**BLOCK 4N CENTRAL PARK – Section 96 Submission
SUMMARY OF CHANGES**

20th January 2016

SOFTWARES PLAN
LEVEL 12-16

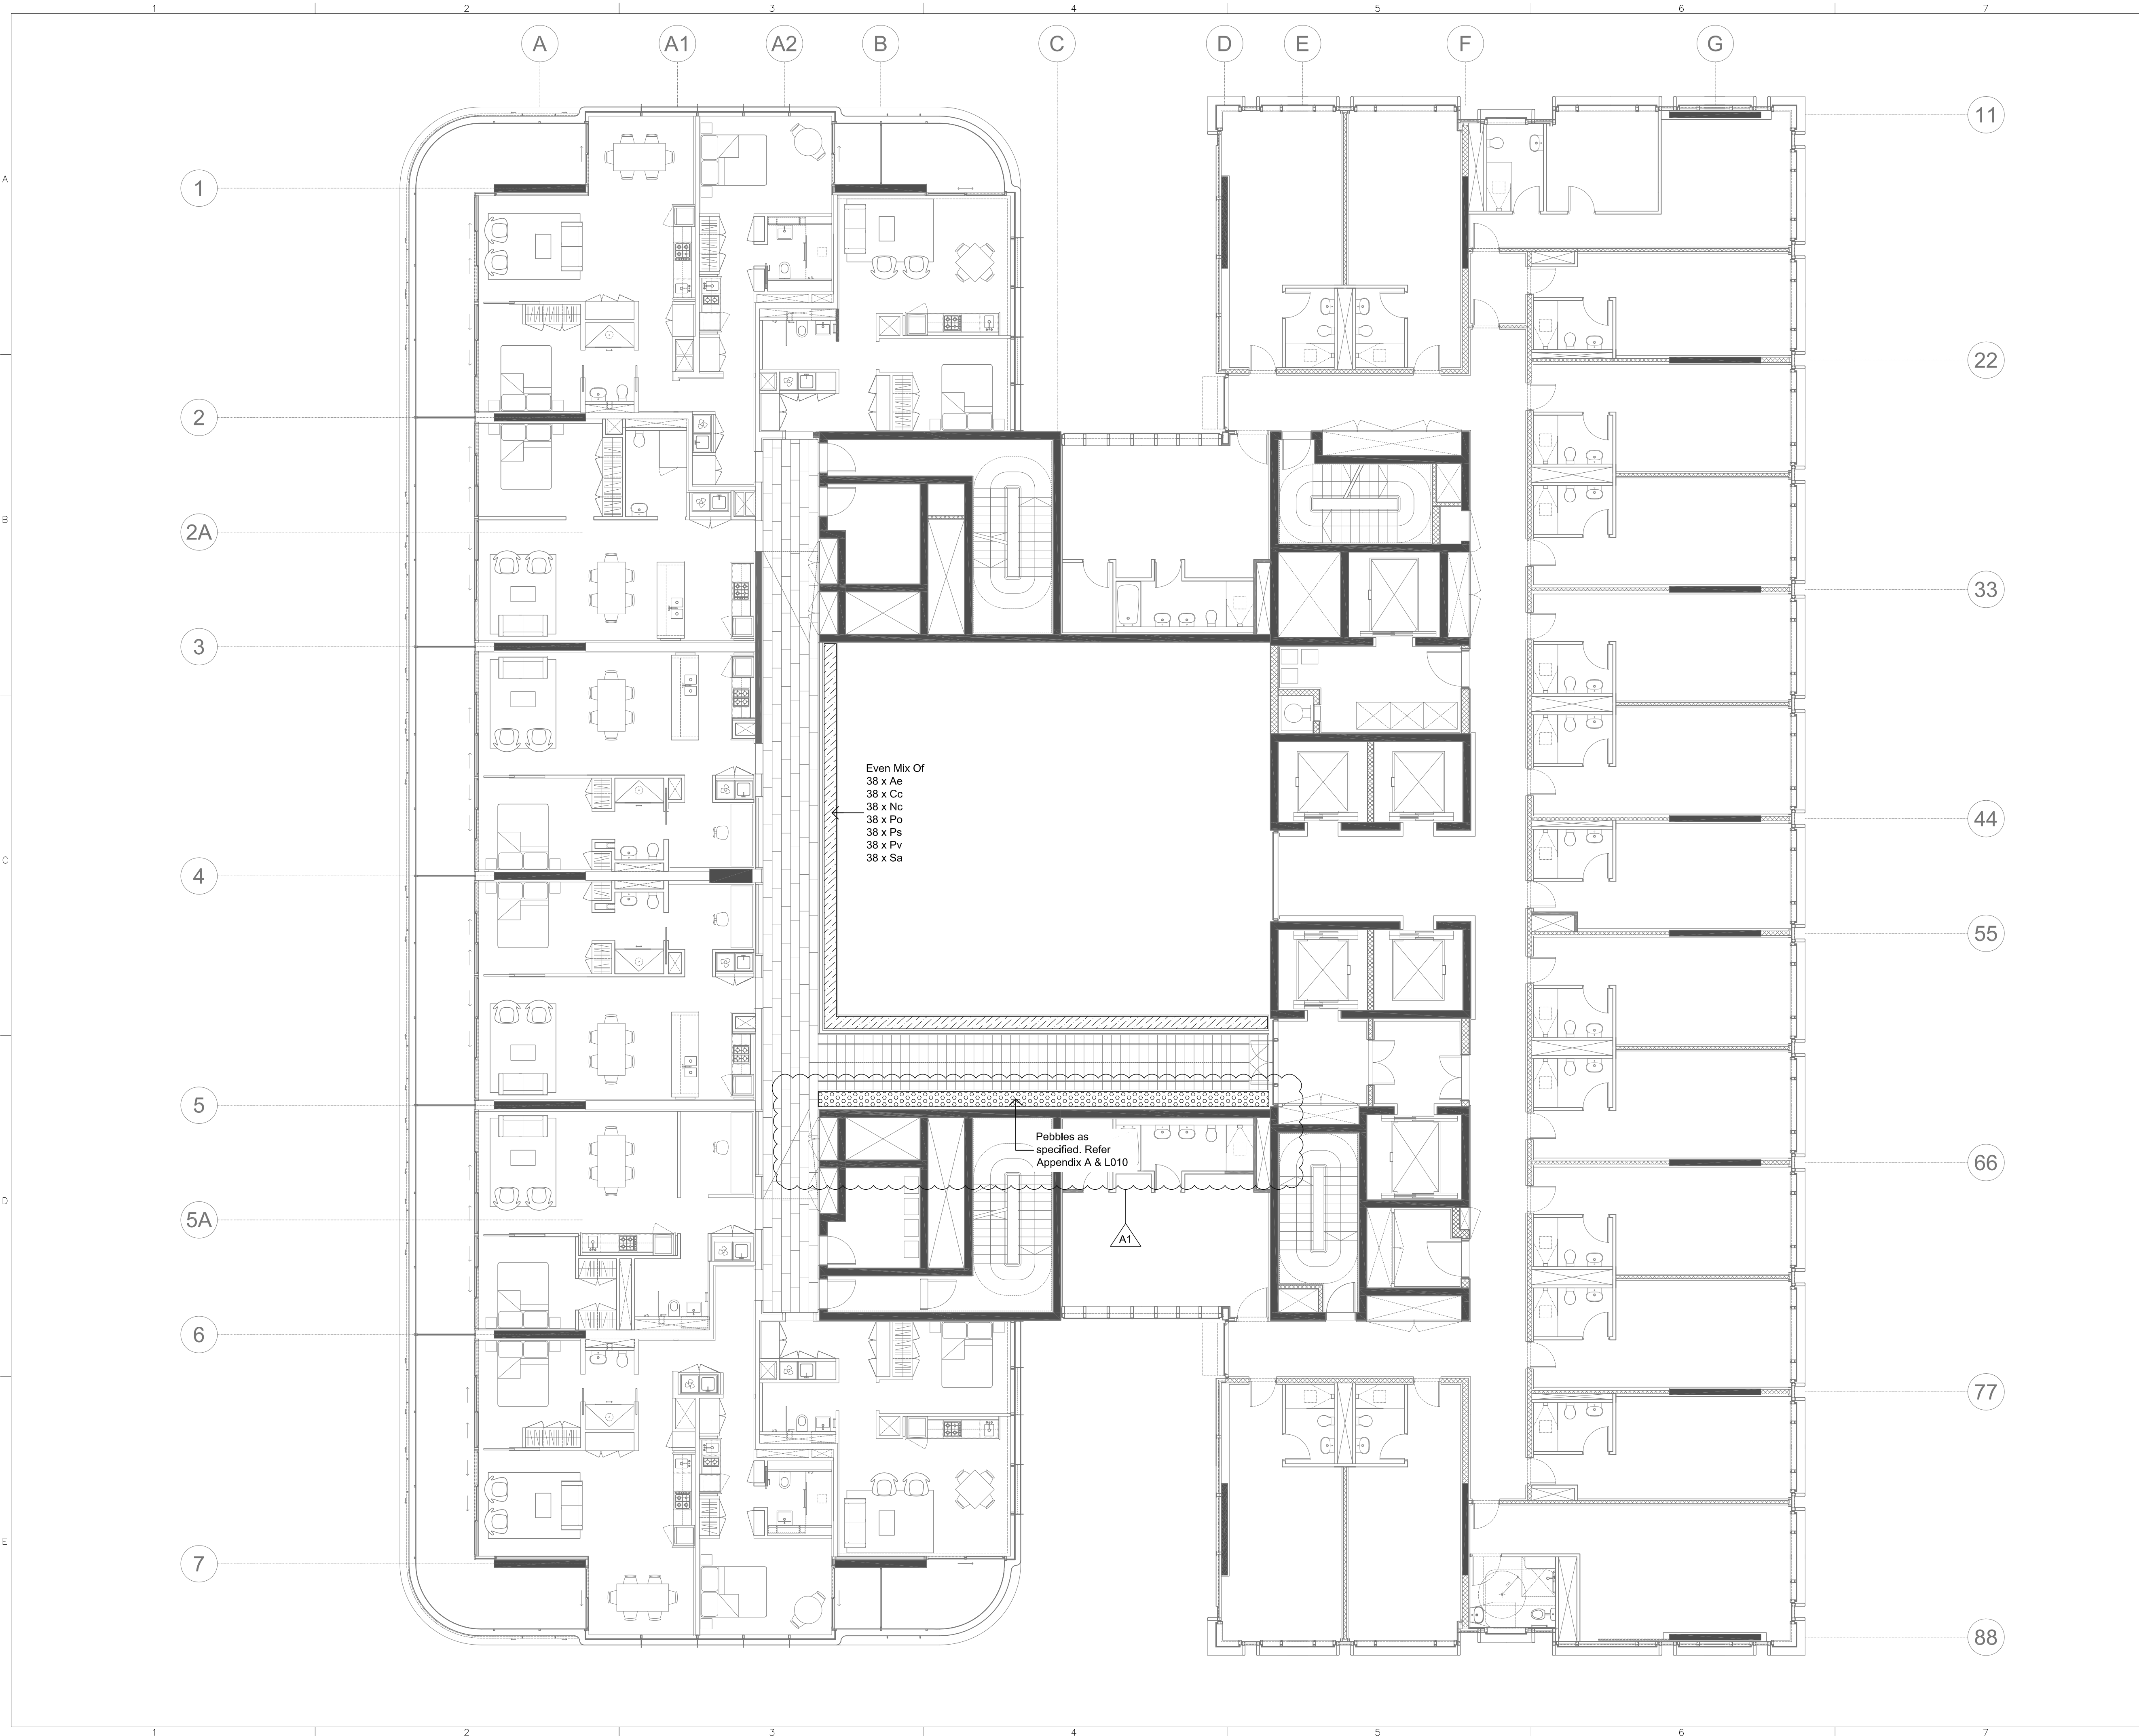
- All water features have been omitted from the project and replaced with soft landscaping and hedges
- The external terrace areas to the Hotel lobby and restaurant have slightly increased in size.
- Planters and raised benches within the internal street have been slightly shifted across to align better with the now updated B1 podium facades.
- The plinth underneath the Restaurant annex on Broadway has been detailed to be clad in large polished grey granite stone slabs with an anti-graffiti coating.

Block 4N  
External Wall System  
Typical Hotel Slot Facade  
Cladding Type H3

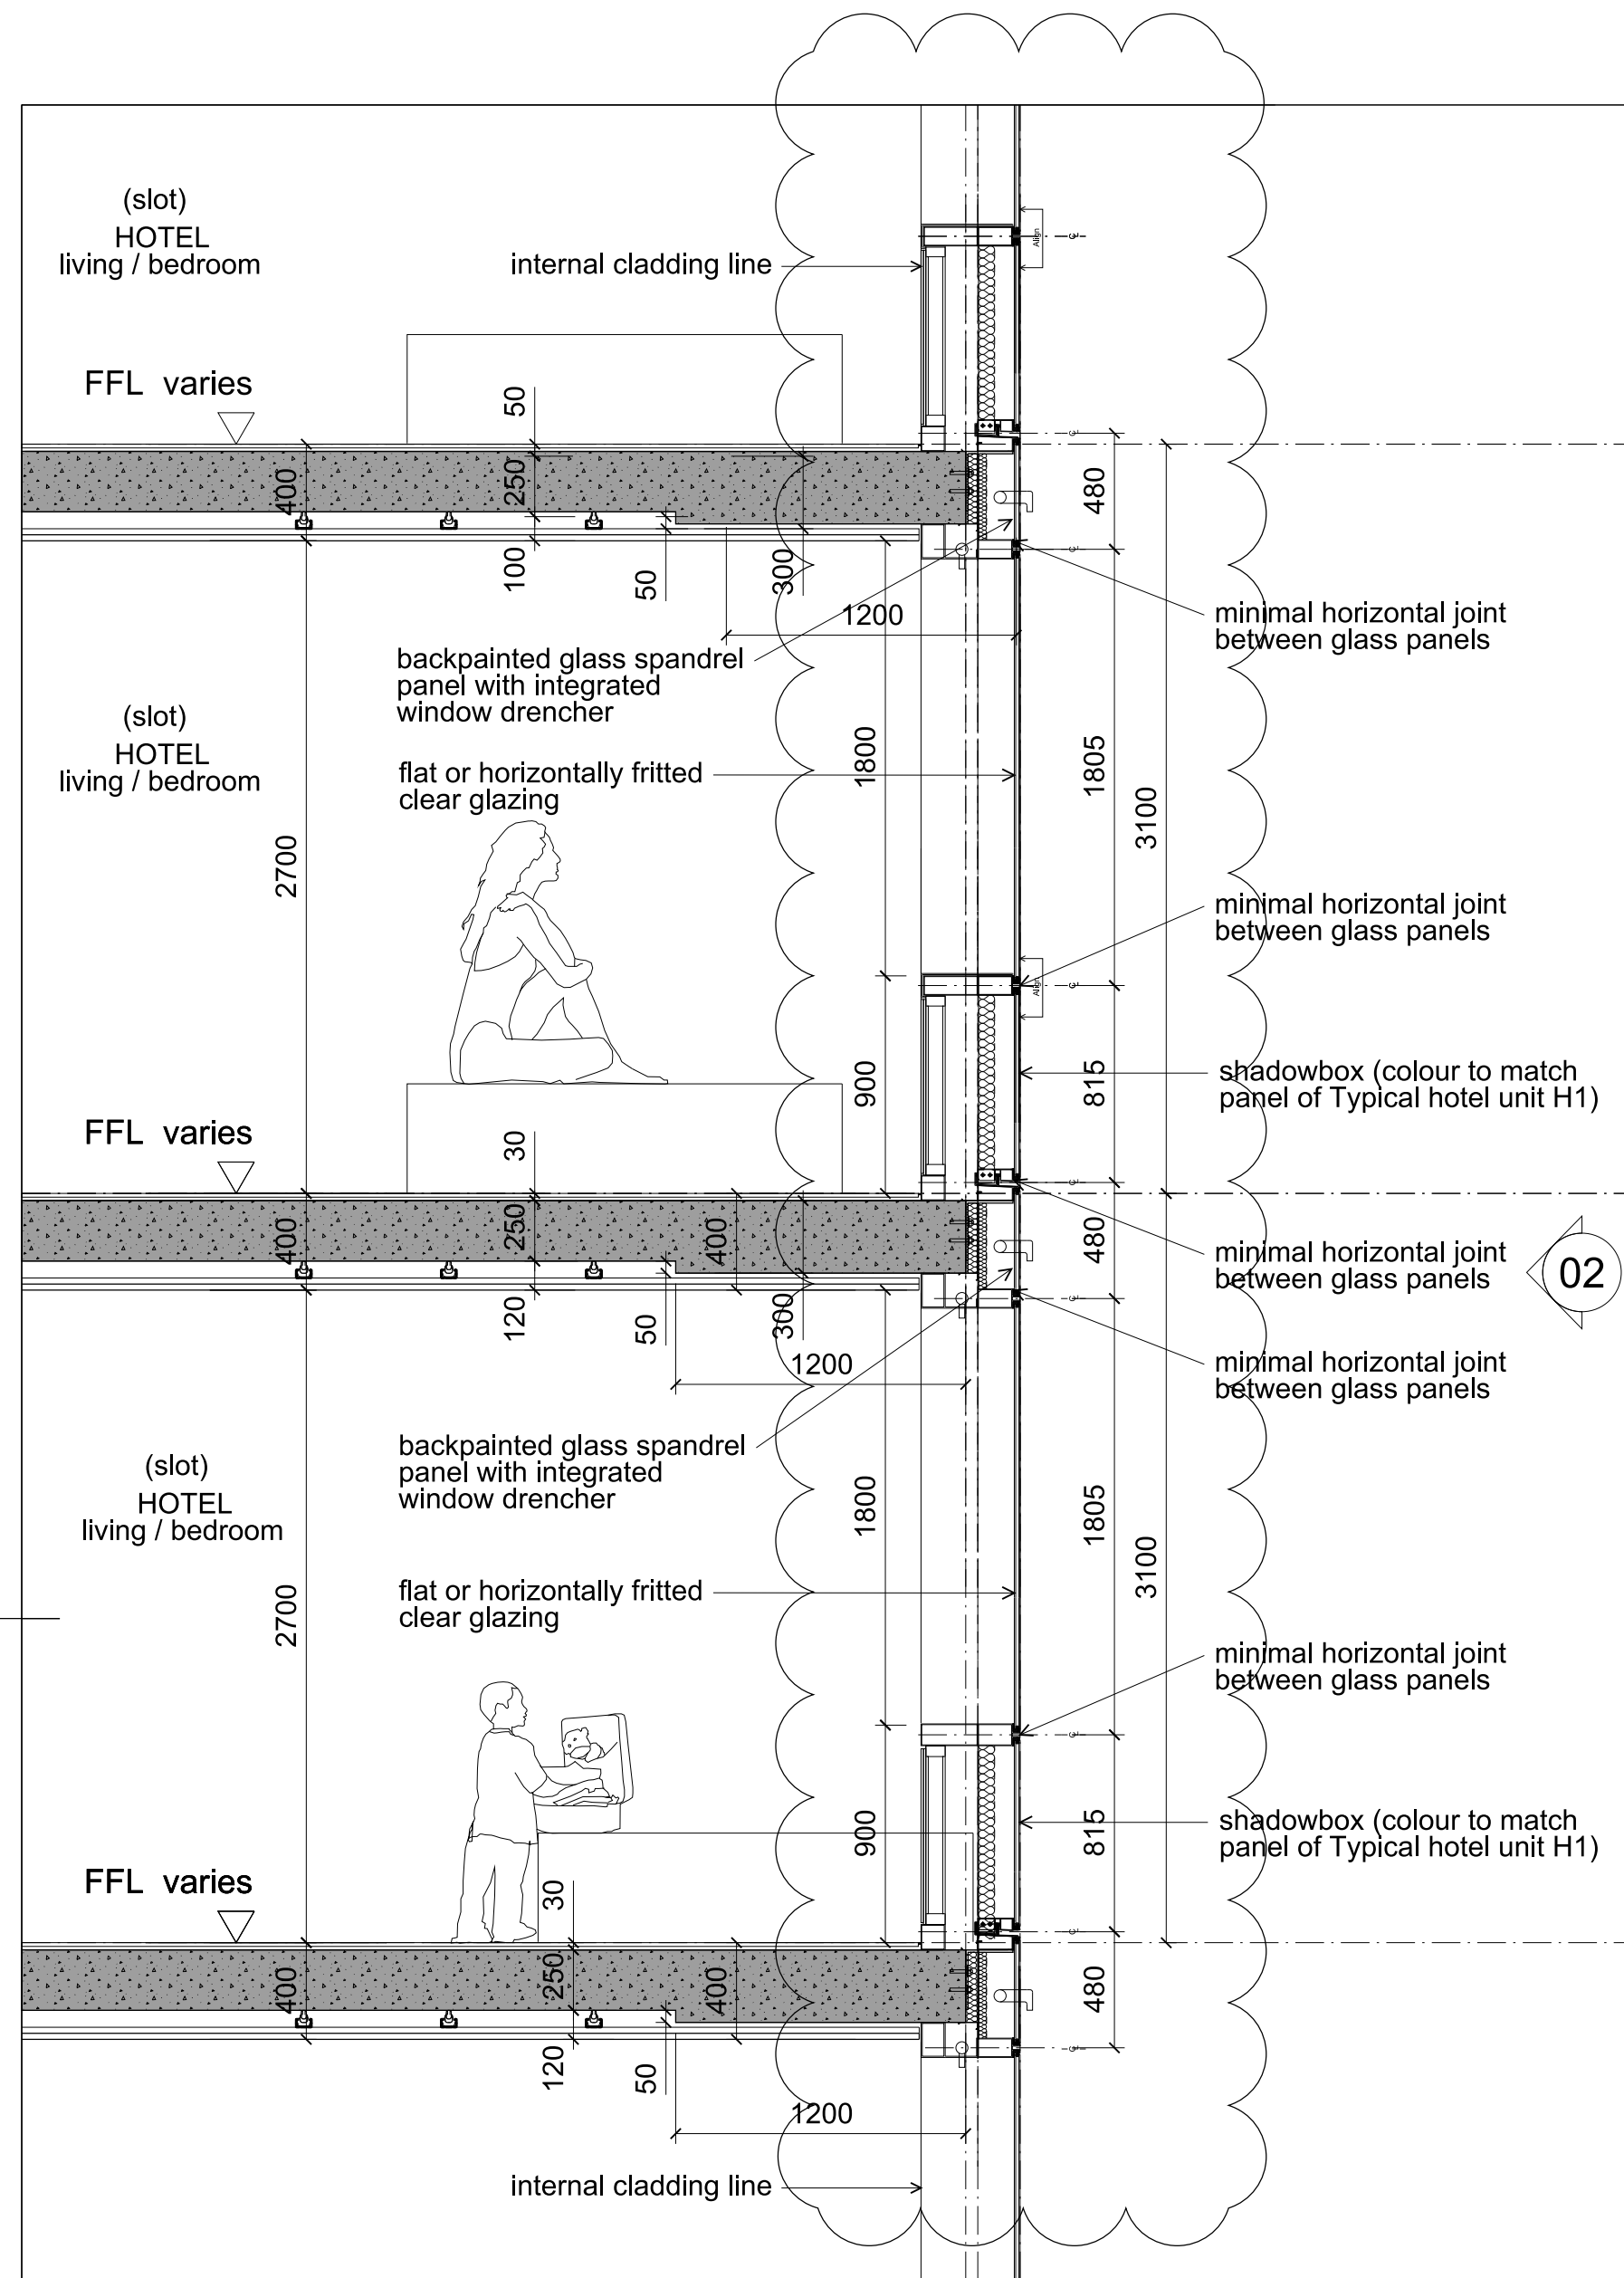
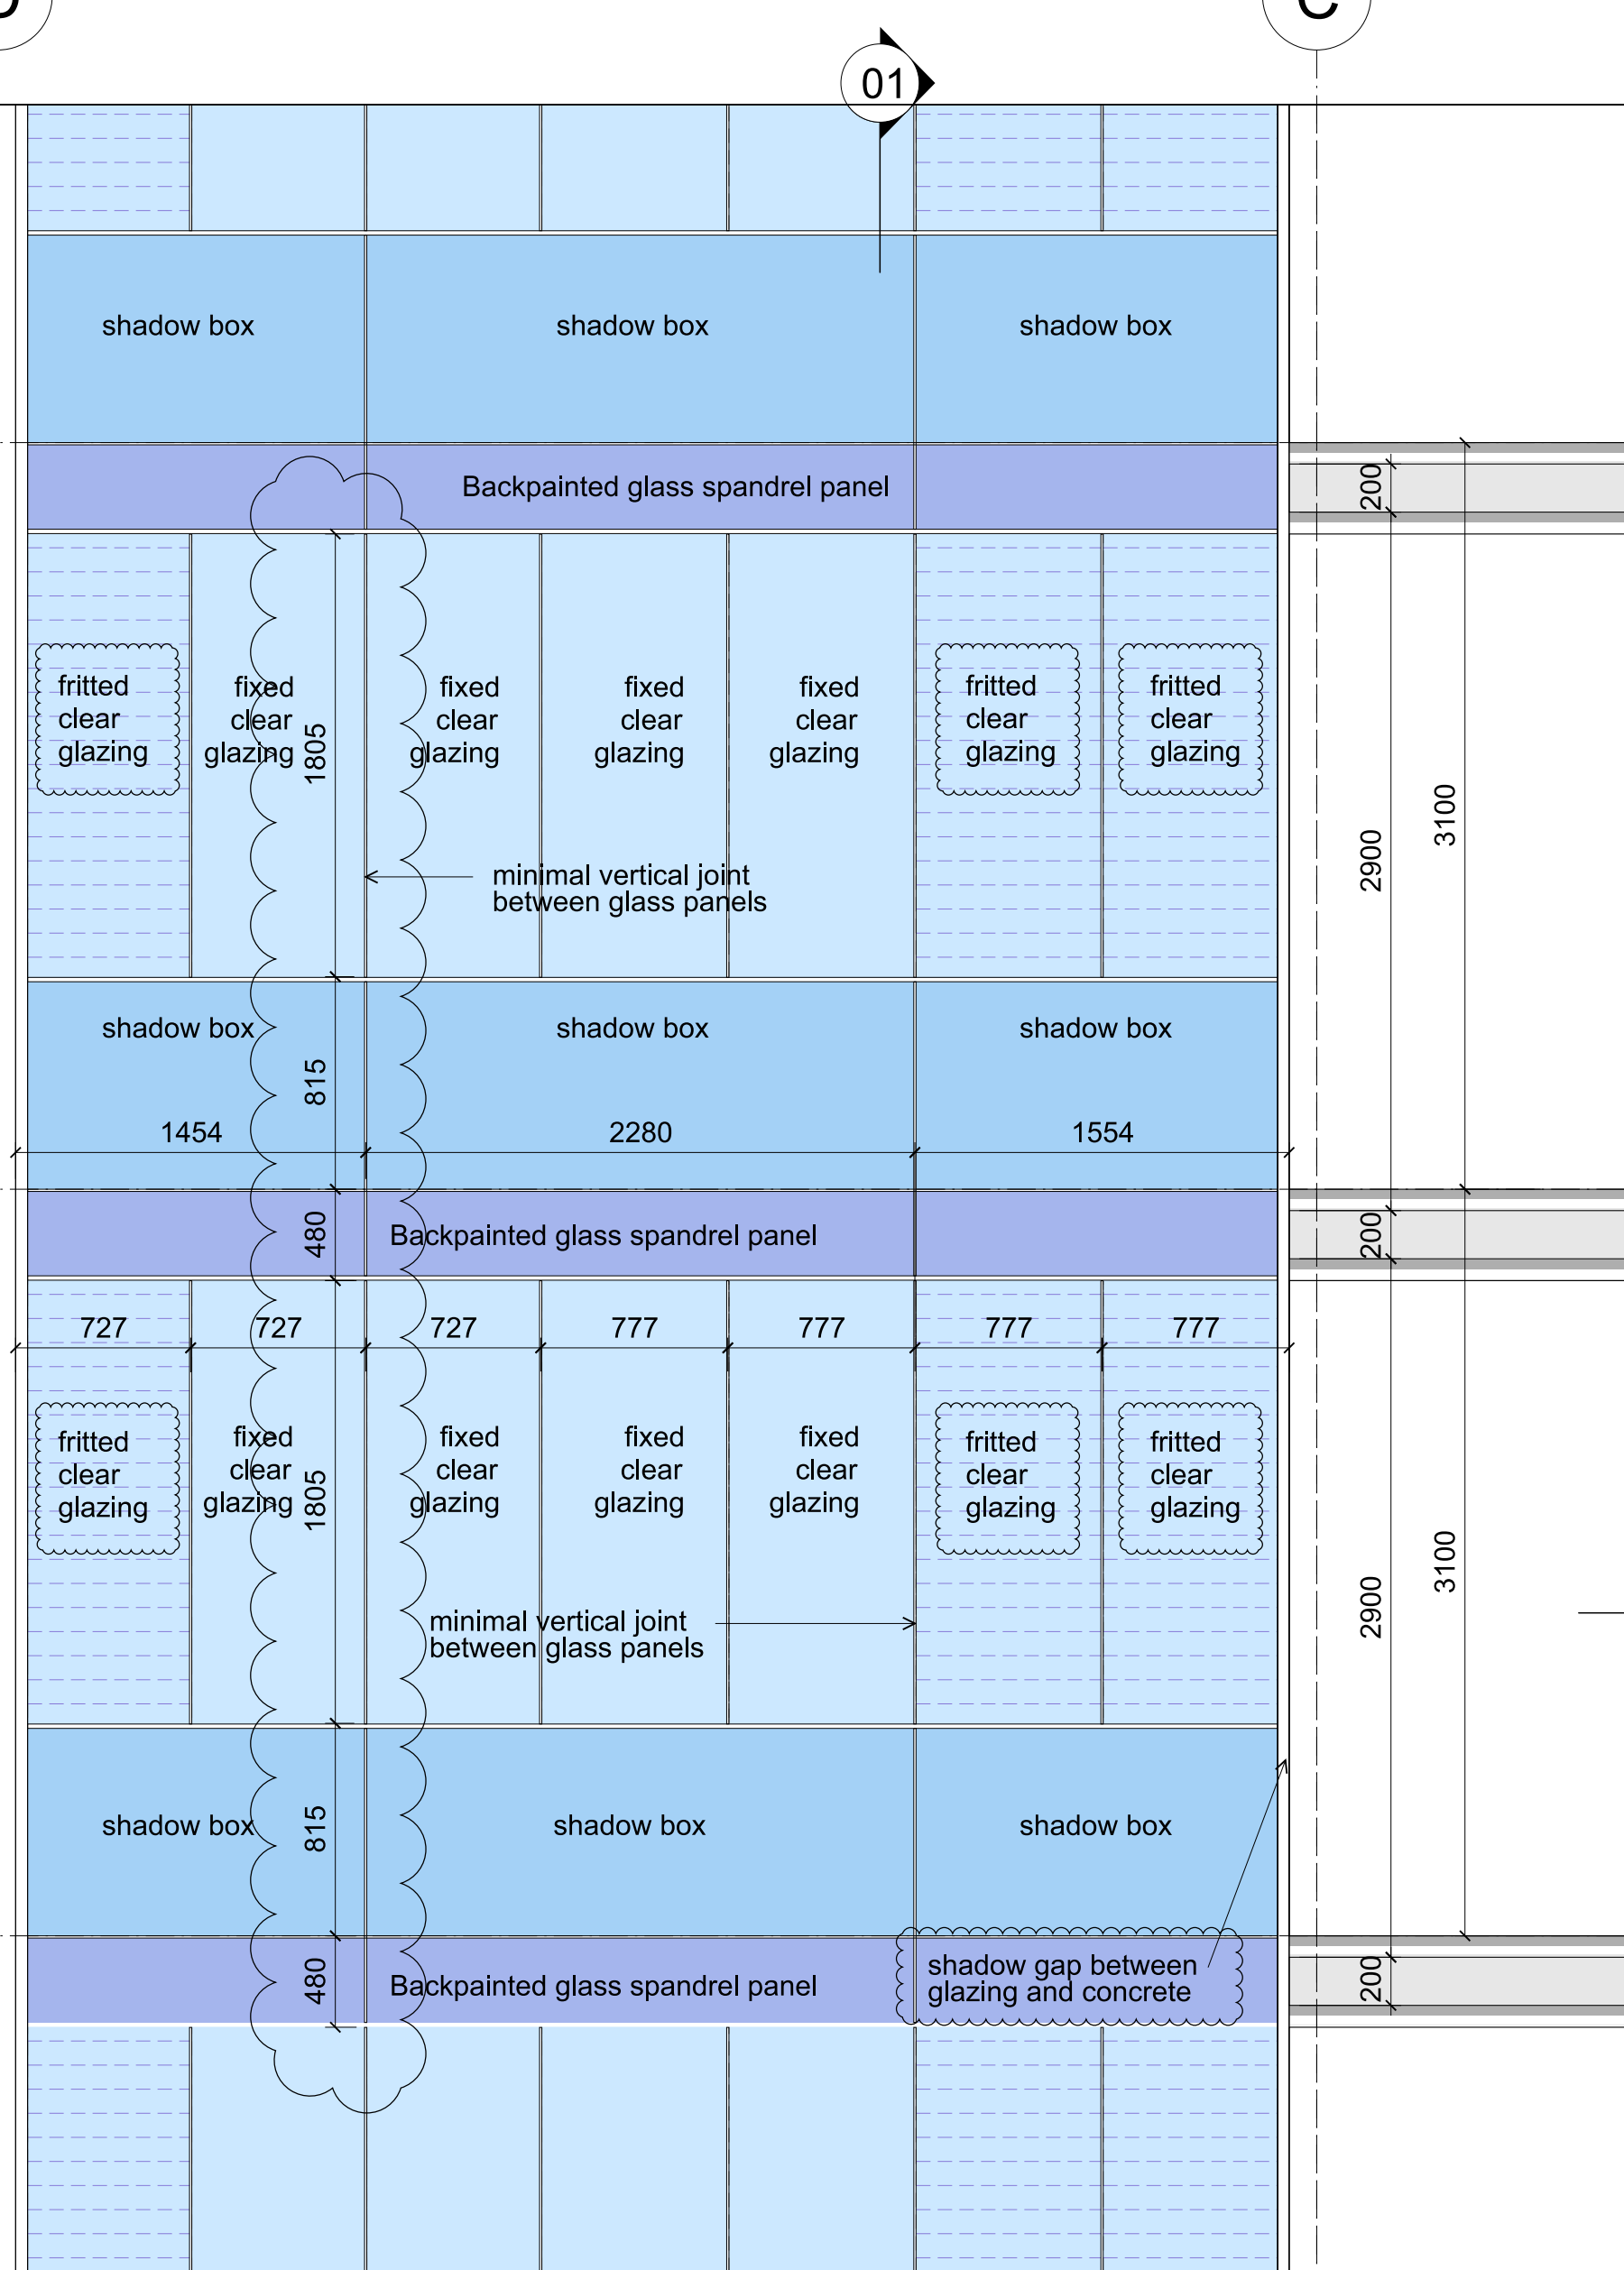
- Frame around the hotel units has been slightly reduced in depth (by 75mm)
- Podium facades elements such as clear glass zone, sunshades and spandrel panels have been slightly re arranged in order to better suit the new hotel operator brief within the podium levels
